TREE CONSERVATION REPORT
ADDENDUM
71 Russell Ave

Tree Conservation Report Addendum submitted as
Partial Requirements for a Site Plan Control
Application, April 10, 2026

Address: 71 Russell Ave

Date of Report: April 10th 2026

1 SECTION: 6.9m TALL RETAINING WALL AT PROPERTY LINE  
SK3 SCALE: 3/4" = 1'-0"

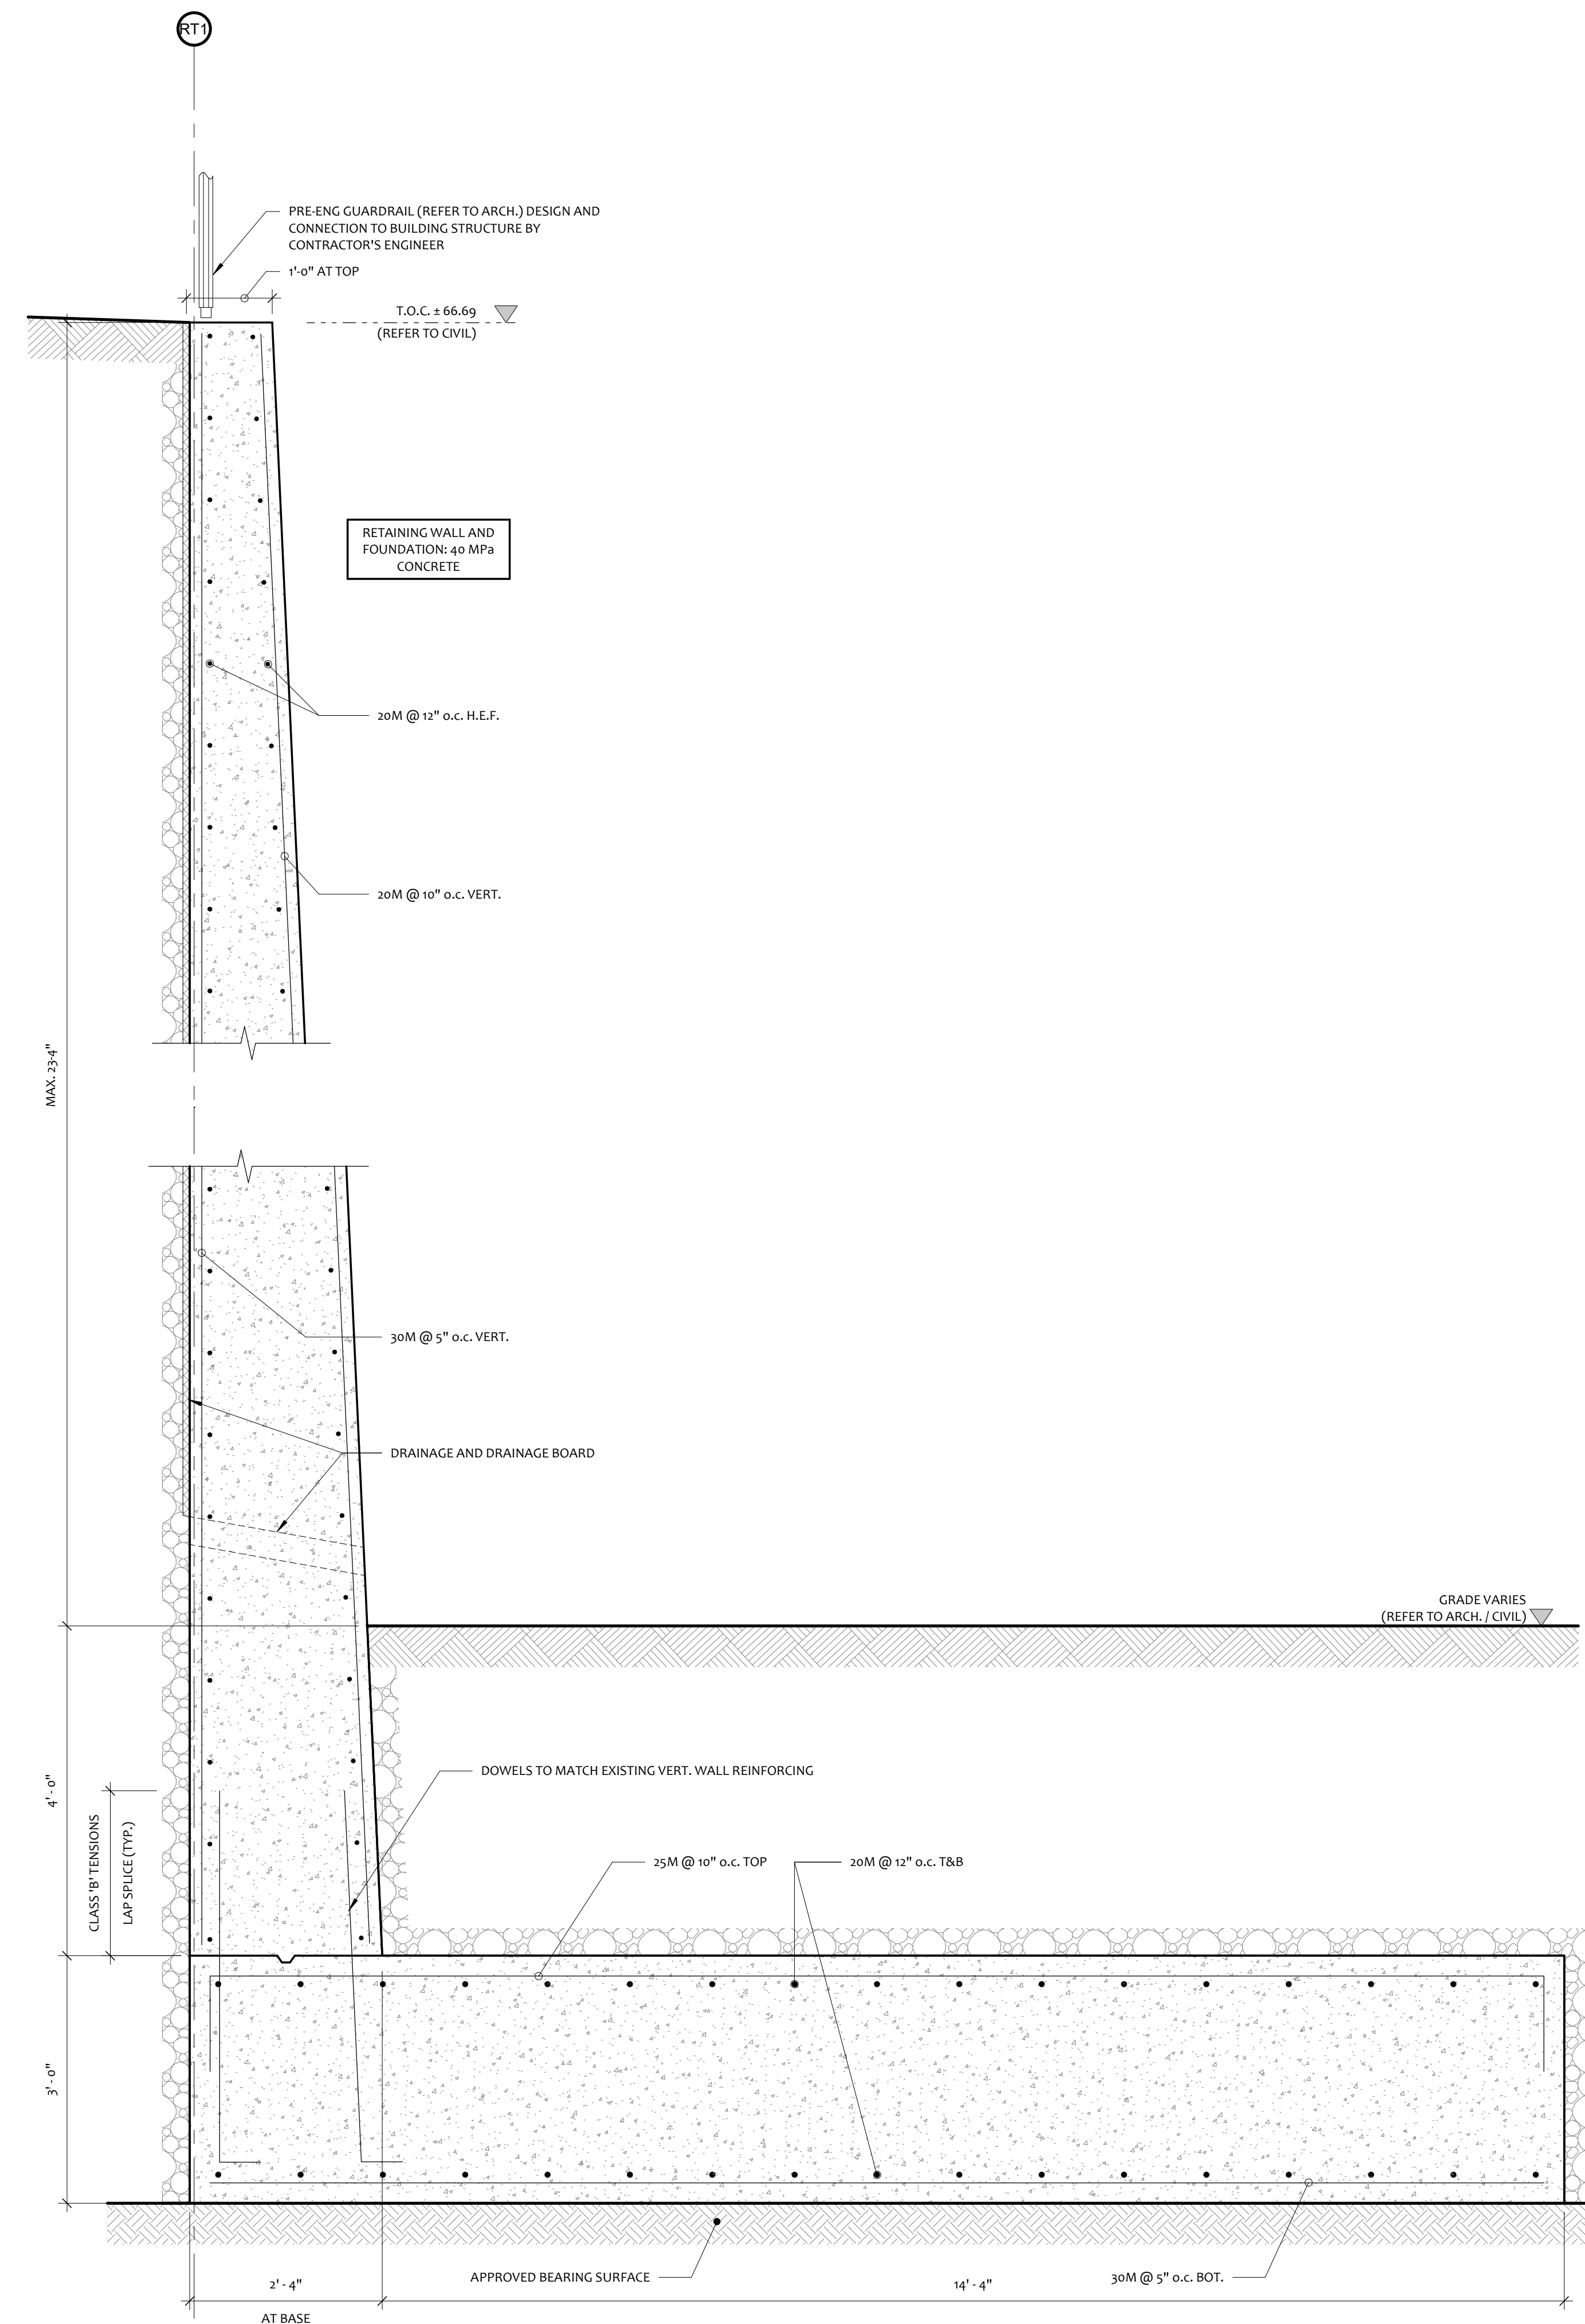
- 1. The retention plan for trees 1, 10 and 11 raises concern. Please provide more detail on the current growing condition of these trees, how much of the CRZs will be impacted by the proposed excavation and how far excavation is from the trunk of each tree. Address how the existing retaining wall beside trees 10 and 11 has influenced root growth and ensure the CRZs of these trees are accurately depicted. For tree 1, the proximity of the pavement and retaining wall is particularly concerning as it appears to be within the trees static root zone. There is concern over trees 1, 10 and 11 being made unstable by the extent of excavation/construction proposed in their proximity.

Tree 10: This tree is located directly on the property line and will be severely impacted by the proposed development. While the building excavation will utilize shoring to limit root disturbance, the construction of the retaining wall requires a grade change exceeding 4 meters. This excavation will effectively eliminate the tree's entire Critical Root Zone (CRZ) on the subject property. Furthermore, the building footprint creates a significant crown conflict, necessitating the removal of approximately 30% of the canopy, including two larger branches. Given the severity of both root and crown impacts, retention is not a safe or viable option. As this tree is situated on the adjacent property, written consent from the owner is required to proceed with a removal permit application.

Photo 1: Existing retaining wall by Tree 10, American elm on adjacent property. The new retaining wall will be over 4 m in depth and flush against the property line which is close to the existing fence

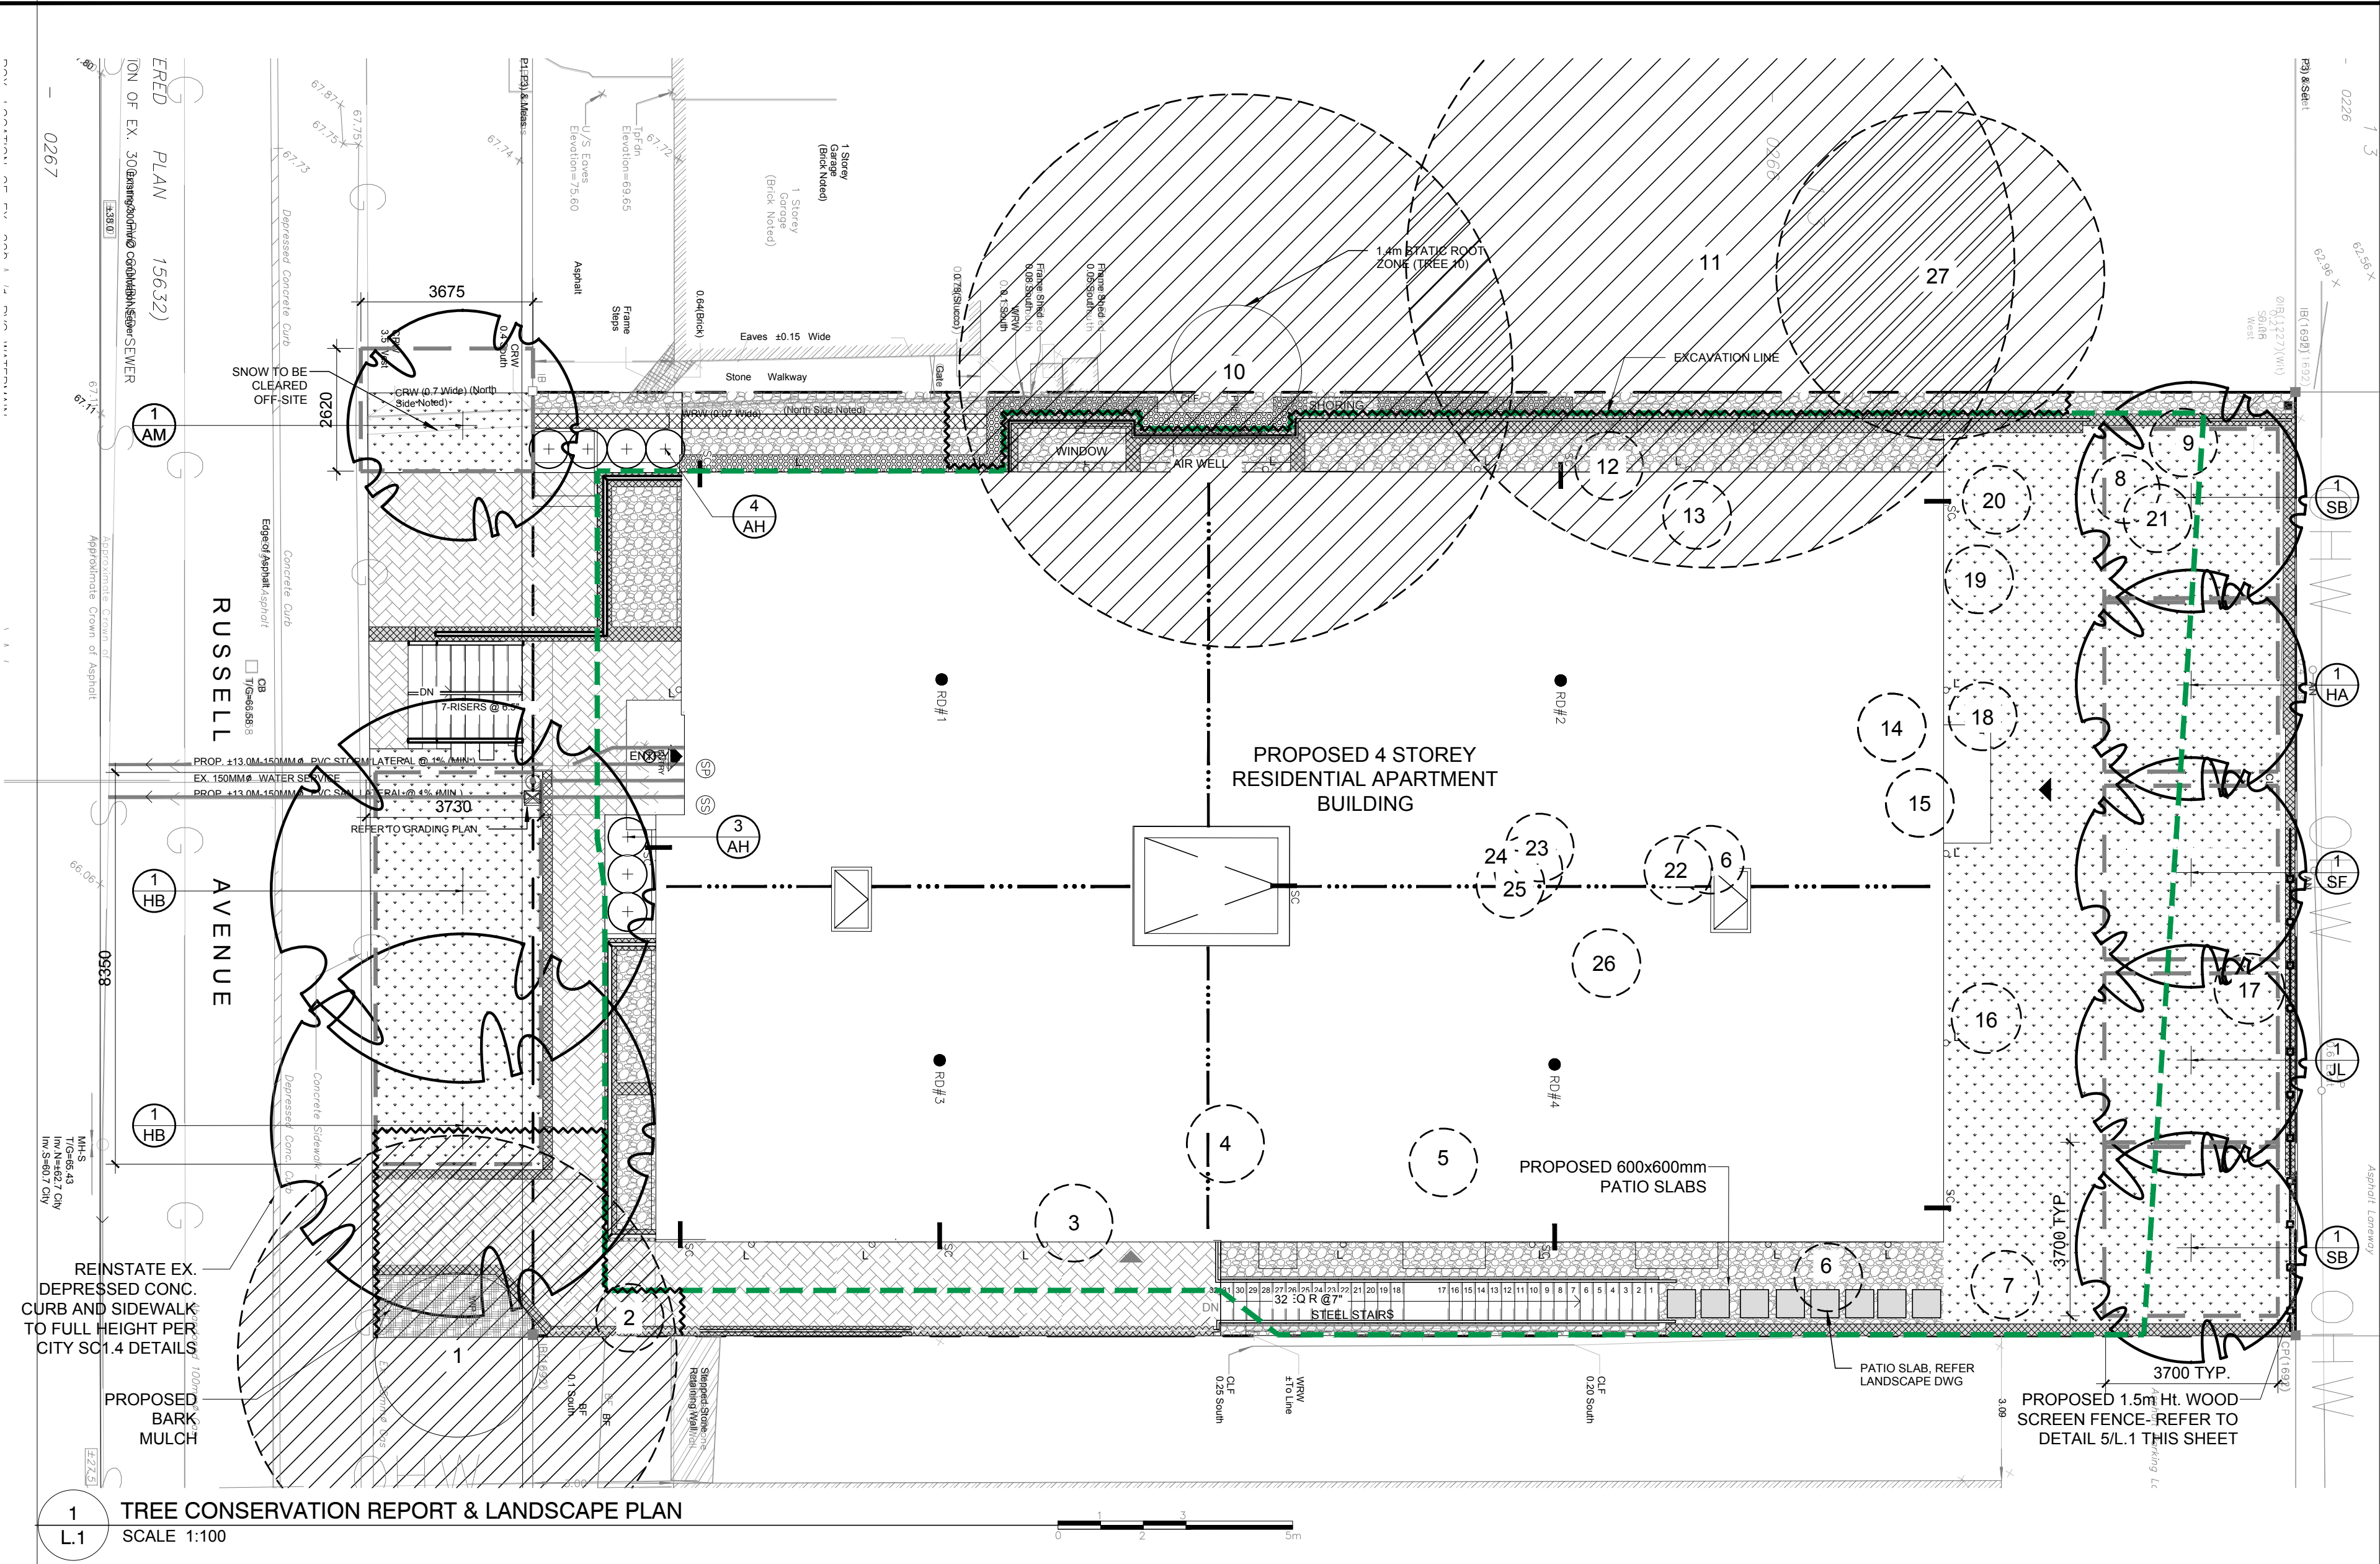
- 4. The tree protection fencing for trees 10 and 11 overlaps with the proposed stairs and with a future talkway and curb for tree 1. This is unrealistic. Please address in the TCR and provide more details on the plan and how it can be executed as planned.

Tree 1: This tree is identified for retention; however, its proximity to the proposed walkway requires specific mitigation measures. Following consultations with Barry Westby from Pinehill, the project will utilize a low-impact installation method to ensure that no stabilizing roots are severed. To guarantee the tree's long-term health, a certified arborist must be present to supervise all work within this area. Furthermore, pre-construction root exploration using an airspade is recommended to help finalize the walkway alignment and minimize root impact. The Tree Protection Zone (TPZ) fencing must remain in place throughout all site works and should only be removed once walkway installation is ready to proceed.

Tree 11: This tree is located on the adjacent property and exhibits a severe structural defect, growing at a nearly horizontal lean. Given its poor condition, the tree may be susceptible to failure triggered by construction-related vibrations. While its removal is not mandatory for the project, it is recommended that the applicant consult with the neighbor to explore this option. At a minimum, any large branches encroaching over the subject property that pose a risk of failure should be pruned.

Prior to any site works, protective fencing should be installed around the Tree Protection Area for tree 1 as indicated in the Tree Conservation Report map and maintained until all construction on site has been completed as per the City of Ottawa Tree Protection Specifications (March 2021).
